6 June 2022

RE: Main Response Report - Kings Park Metal Recovery and Recycling Facility Expansion (SSD-10396)

1.0 Department of Planning and Environment

Figure 3-4: Plan of overall Proposal site showing proposed acoustic wall (indicated by green line)

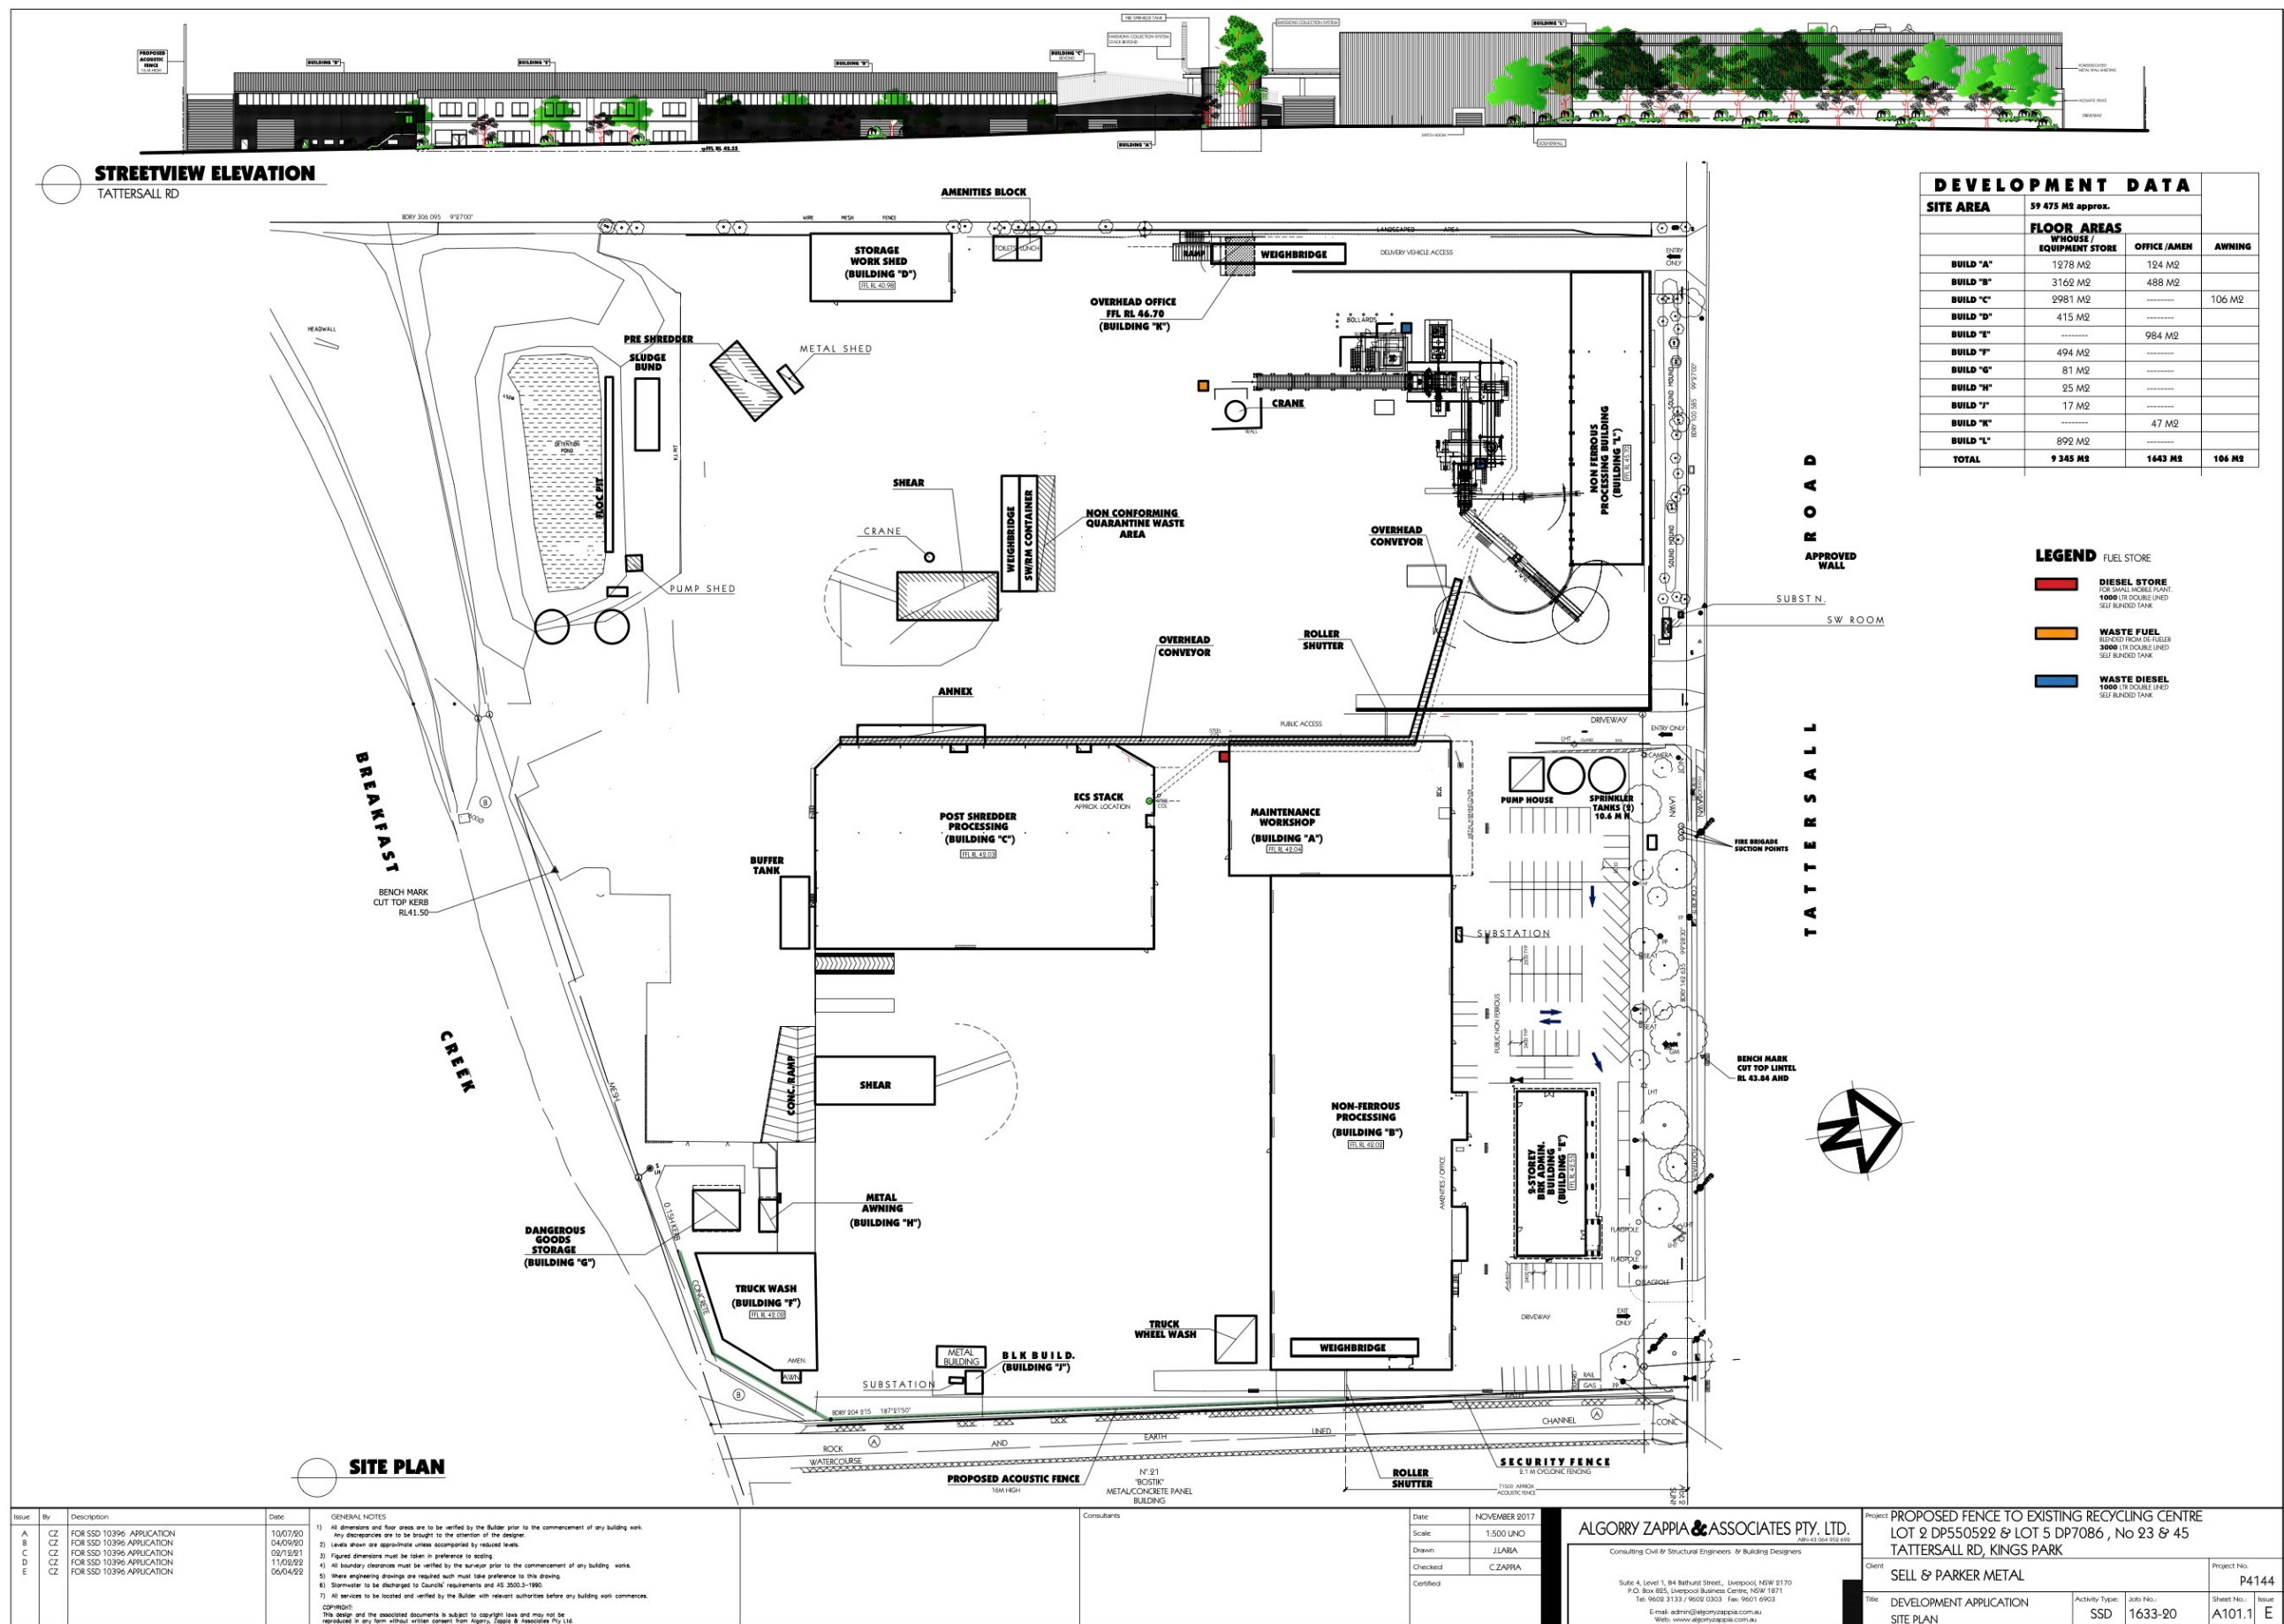
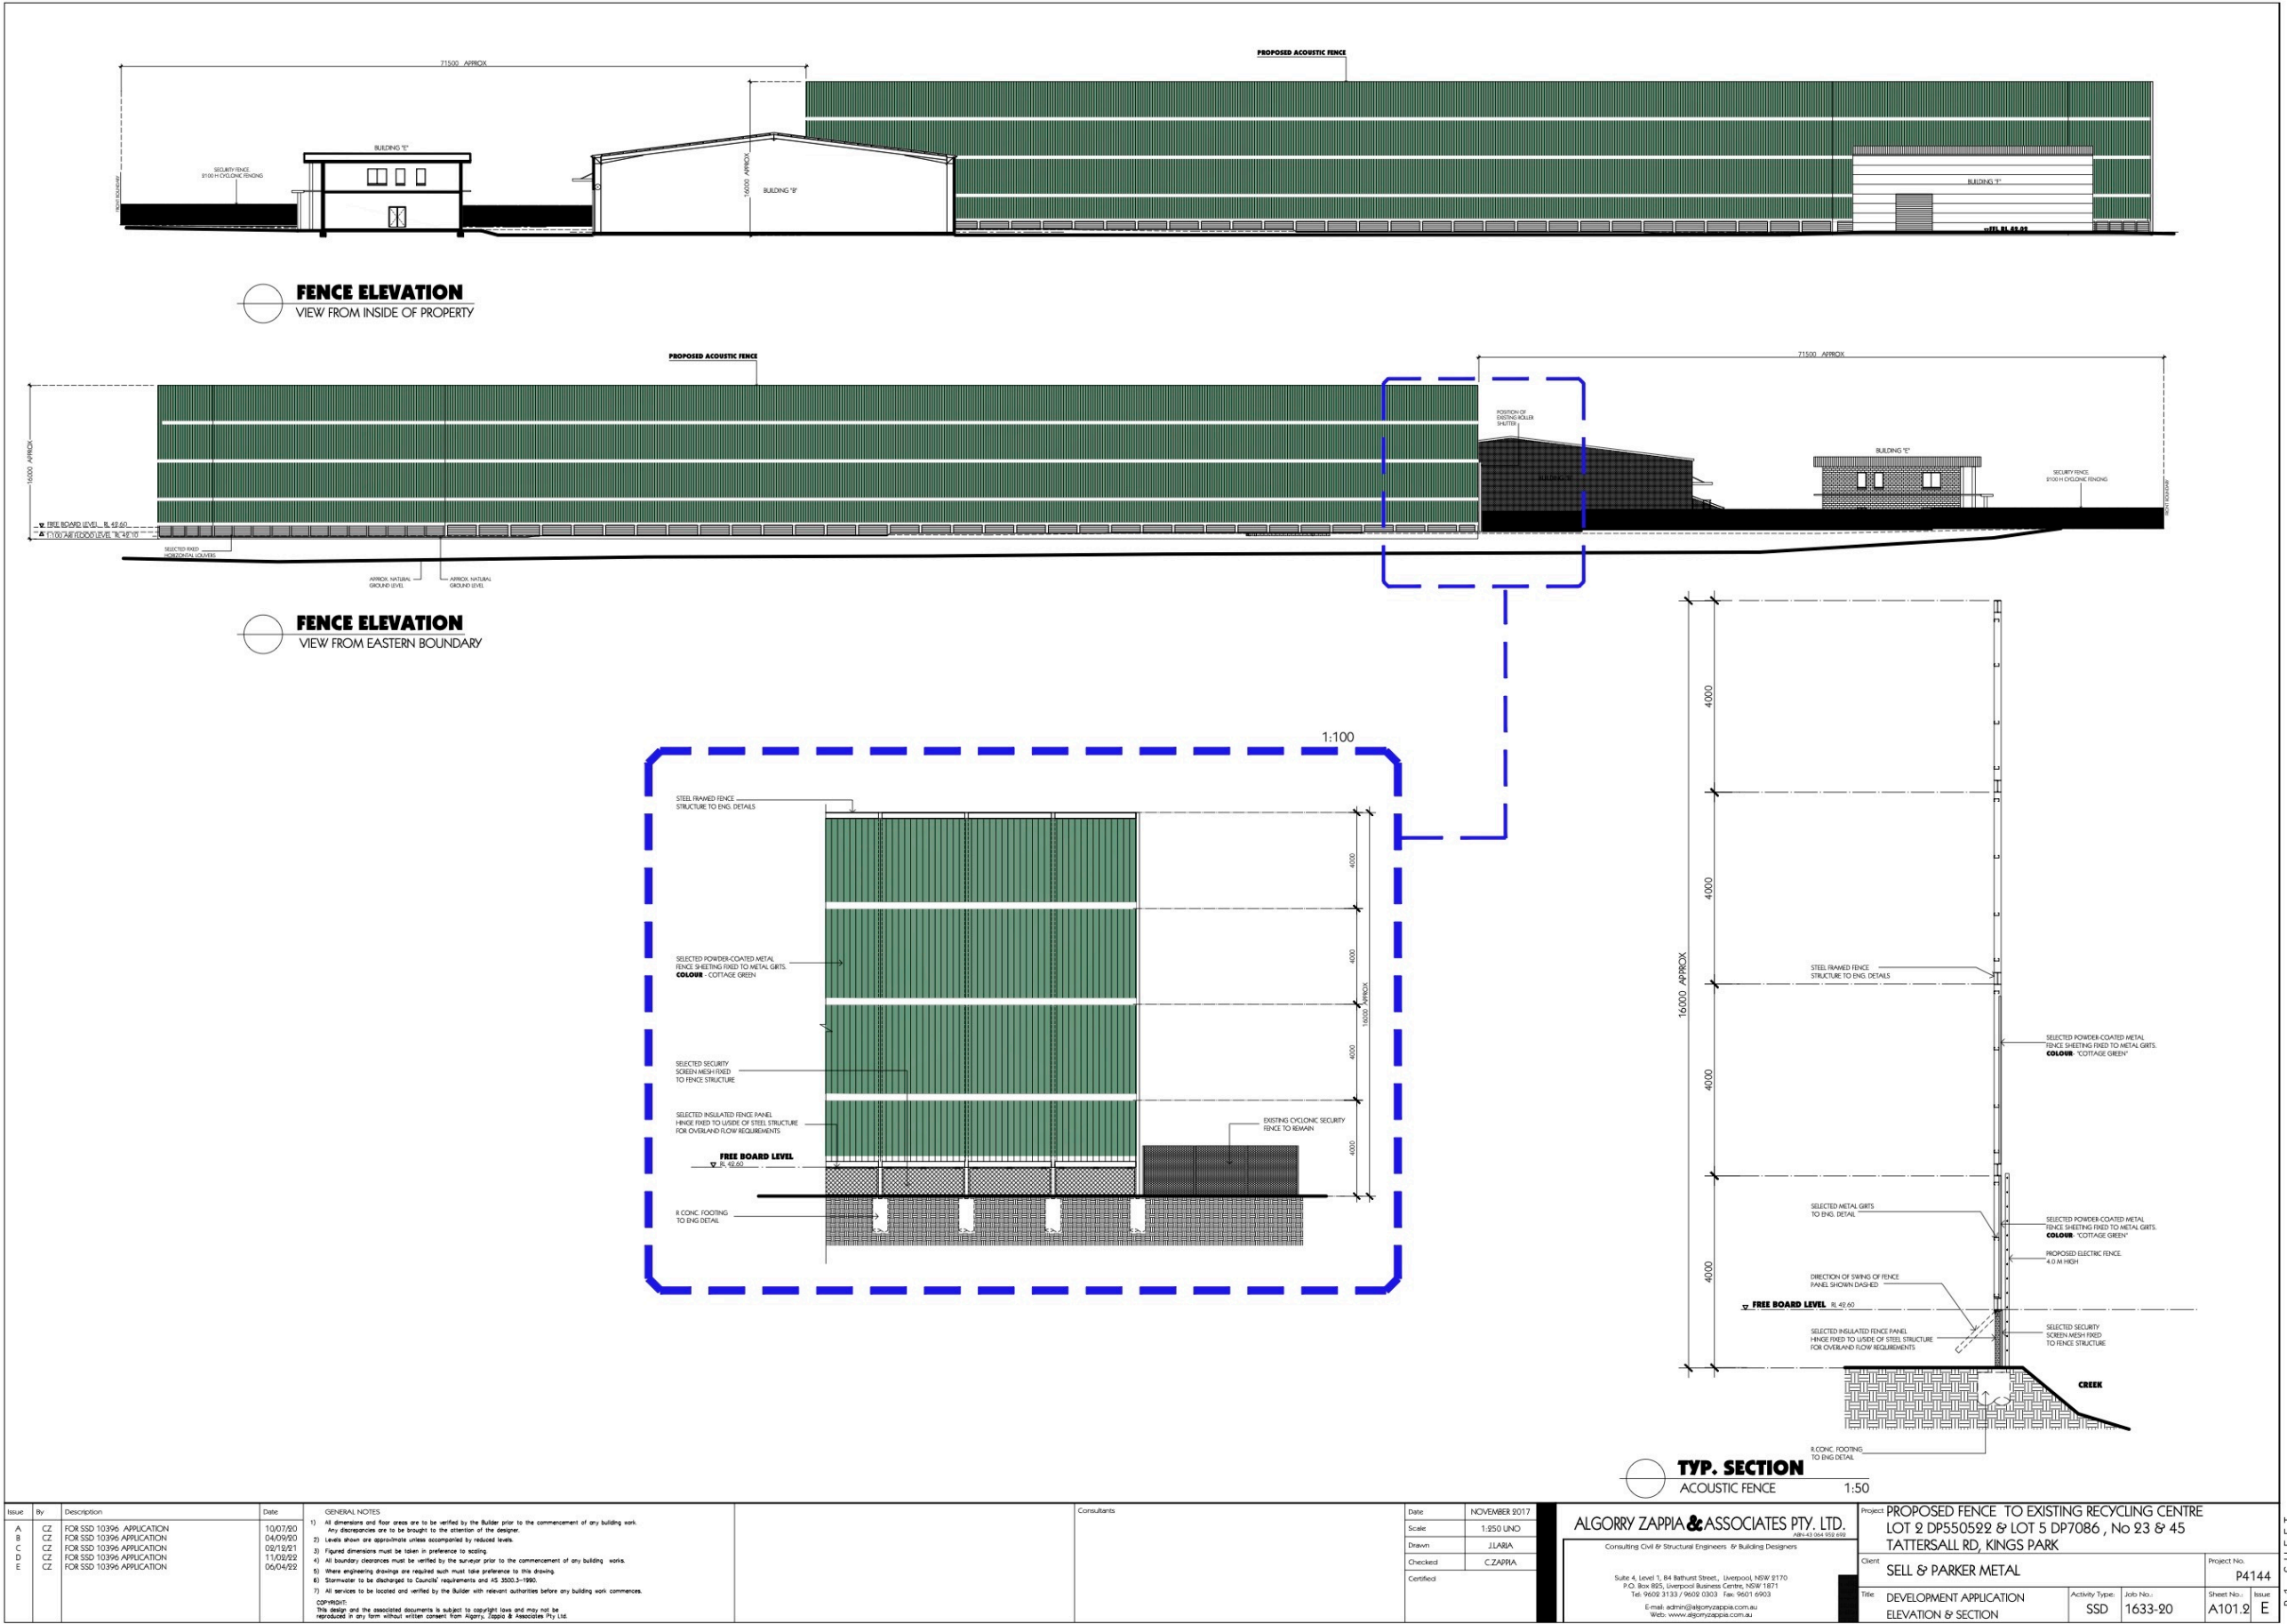
Provide plans (including elevations and sections) of the proposed 16 m high noise wall along the south-eastern boundary of the site and ensure all site plans include the proposed noise wall.	A Site Plan and Acoustic Fence Layout, which includes this detail, has been provided at <i>Attachment E</i> of this response.	Site Plan and Acoustic Fence Layout (Attachment E of this response)
Visual Impact Assessment	Provide a detailed visual impact assessment (including photomontages and perspectives) of the proposed noise wall, including height and scale, materials and finishes and colours. Please ensure the assessment responds to Council's comments dated 20 January 2022 and also addresses potential impacts to adjacent industrial facilities.	A detailed Visual Impact Assessment (VIA) (including photomontages and perspectives) has been provided in <i>Attachment F</i> of this response. This VIA responds to Council's comments (refer to Section 3 of this response). The Site Plan and Acoustic Fence Layout, also includes further detail (refer to <i>Attachment E</i> of this response).	VIA (Attachment C of this response) Site Plan and Acoustic Fence Layout (Attachment B of this response)

Aspect	Issue	Response	Reference
Planning Issues	 a. Both the: submitted document - which aims to address neighbouring concerns Addendum Noise Impact Assessment prepared by Renzo Tonin & Associates and dated 20 December 2021, outline the need for and the applicant's intention to increase the acoustic barrier from 8 to 16m along the eastern boundary. However, the specific details of the proposed acoustic barrier have not been clearly shown on the site and elevation plans. 	A Site Plan and Acoustic Fence Layout, which includes this detail, has been provided at <i>Attachment E</i> of this response.	Site Plan and Acoustic Fence Layout (Attachment E of this response)

b. Additional information is required to illustrate clearly the proposed location, length, construction materials and potential impacts of the proposed acoustic barrier. The potential impacts for the site and surrounding properties, have not been adequately considered in the applicant's response, in particular: neighbourhood amenity, the bulk, scale and shadow impacts of the barrier the potential streetscape impacts specifically if the proposed 16m acoustic barrier is orientated towards the nearby residential area. Insufficient streetscape views and treatment details have been provided. 	A detailed VIA (including photomontages and perspectives) has been provided in <i>Attachment C</i> of this response to respond to Council's comments. The Site Plan and Acoustic Fence Layout, also includes further detail (refer to <i>Attachment B</i> of this response). Shadow diagrams have not been provided and are not considered necessary as the acoustic fence is not anticipated to result in unreasonable over shadowing impacts to sensitive receivers (i.e. restricted to the surrounding industrial context). In particular, shadows are anticipated to be confined to the Proposal site and the channel to the east of the Proposal site.	VIA (Attachment F of this response) Site Plan and Acoustic Fence Layout (Attachment E of this response)
